RE: El Burrito Restaurant
1624 Buffalo Lake Road
Sanford, NC 27332

Application Number: BCOM2002-0004

Thank you for submitting the plans for El Burrito Restaurant. The plans have been carefully reviewed by a qualified code enforcement official to examine for full compliance with the North Carolina Fire Prevention Code and all other fire protection regulatory documents. There are some items that were found during the plan review process that need to be addressed before a final inspection of the new facility can be given. These items are outlined and described below.

# UL 300 HOOD FIRE SUPPRESSION SYSTEM

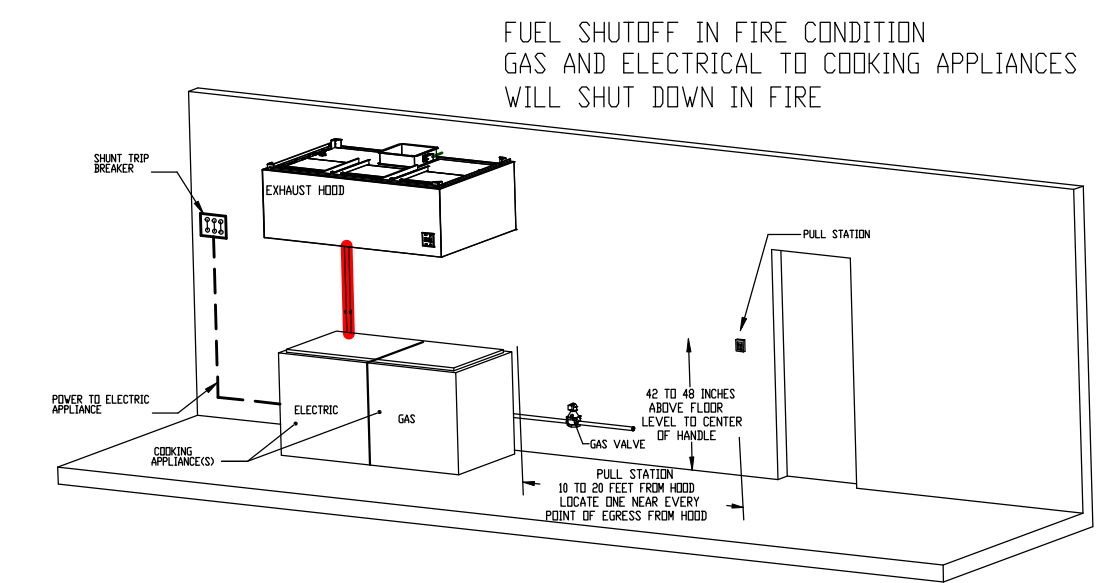
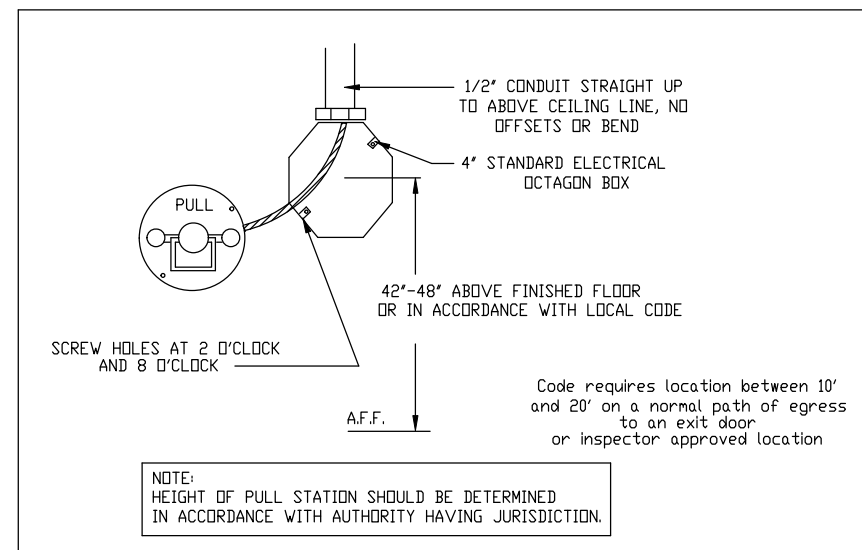
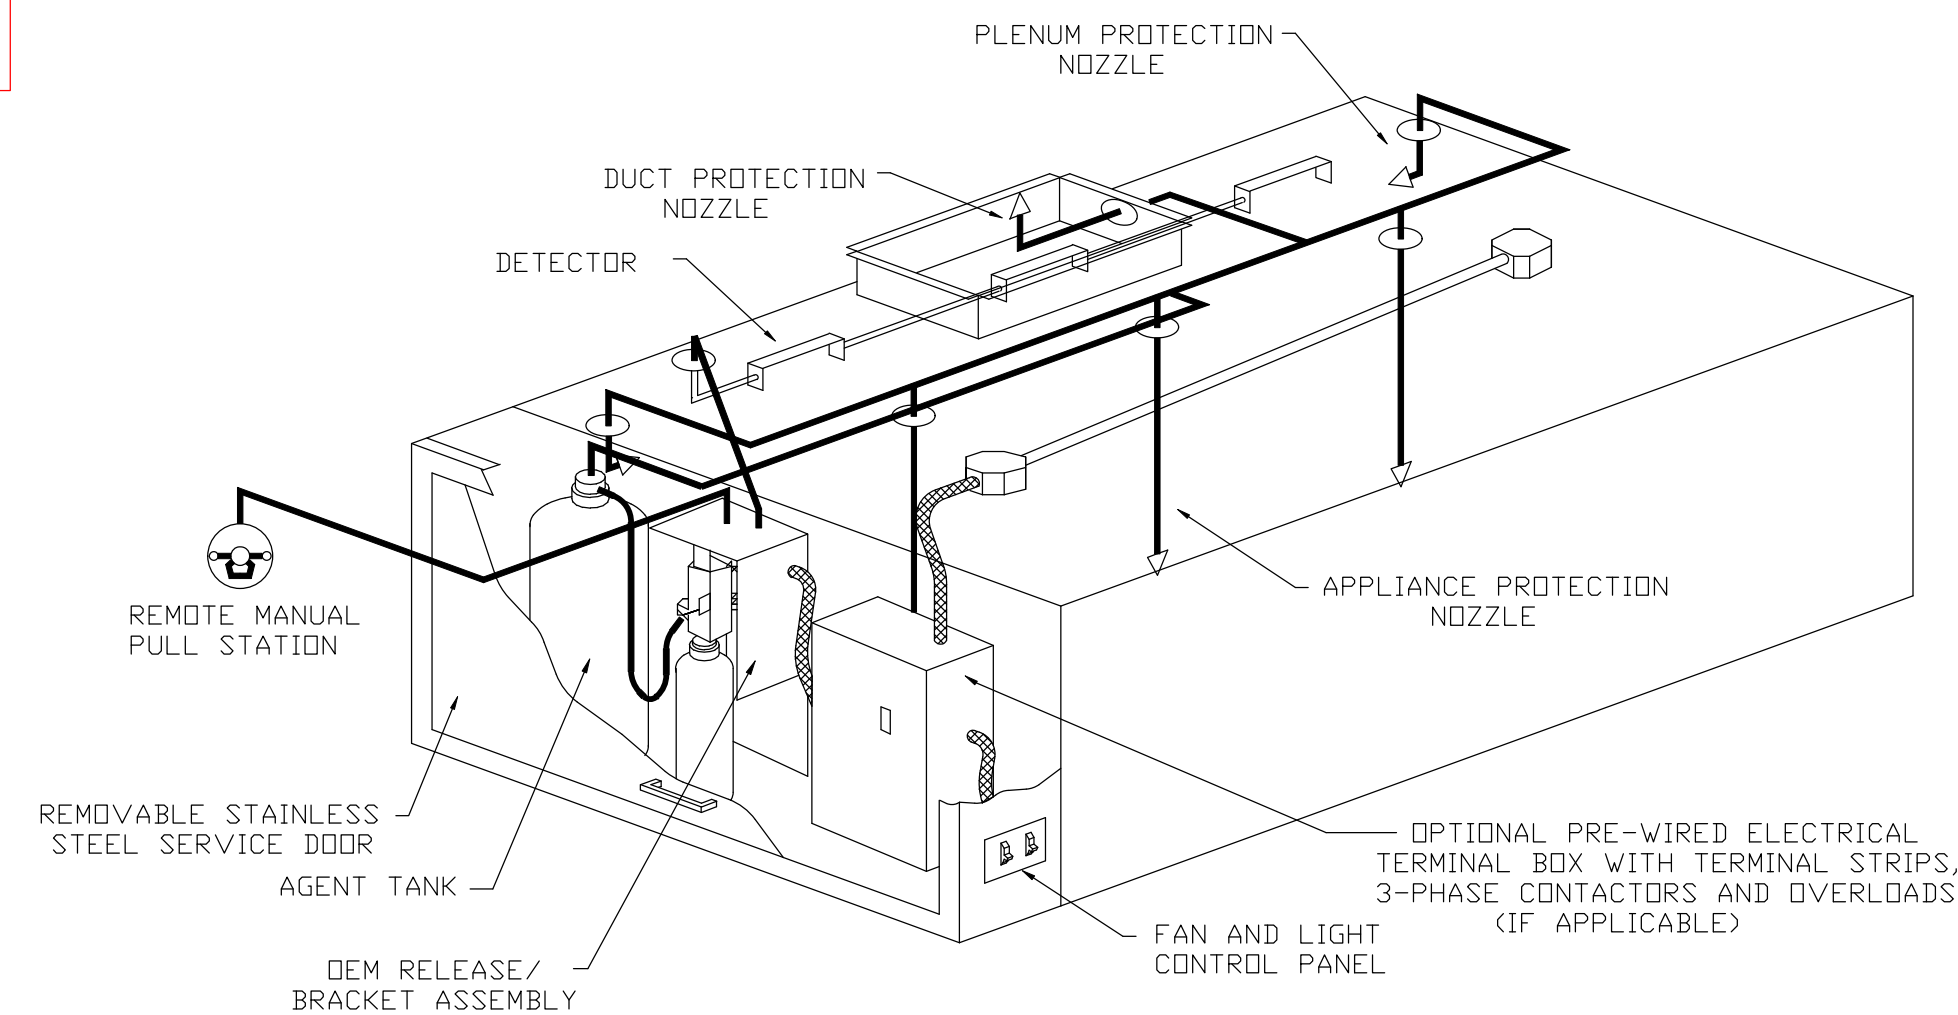
- **901.2 Construction documents**
 - Full detailed plans must be submitted and approved prior to installation of commercial hood system.
 - An acceptance test will be conducted by the Fire Marshal's office once system has been installed and pre-tested.

- Installation shall be per architectural and system submittals and compliant with NFPA-17A.

- **904.12.1 Manual system operation of Commercial Hood System**
 - A manual actuation device shall be located at or near a means of egress from the cooking area, a minimum of 10 feet (3048 mm) and a maximum

of 20 feet (6096 mm) from the kitchen exhaust system. The manual actuation device shall be located a minimum of 4.5 feet (1372 mm) and a maximum of 5 feet (1524 mm) above the floor. The manual actuation shall require a maximum force of 40 pounds (178 N) and a maximum movement of 14 inches (356 mm) to actuate the fire suppression system.

- **904.12.2 System Interconnection of Commercial Hood System**
 - The actuation of the fire suppression system shall automatically shut down the fuel or electrical power supply to the cooking equipment. The fuel and electrical supply reset shall be manual.
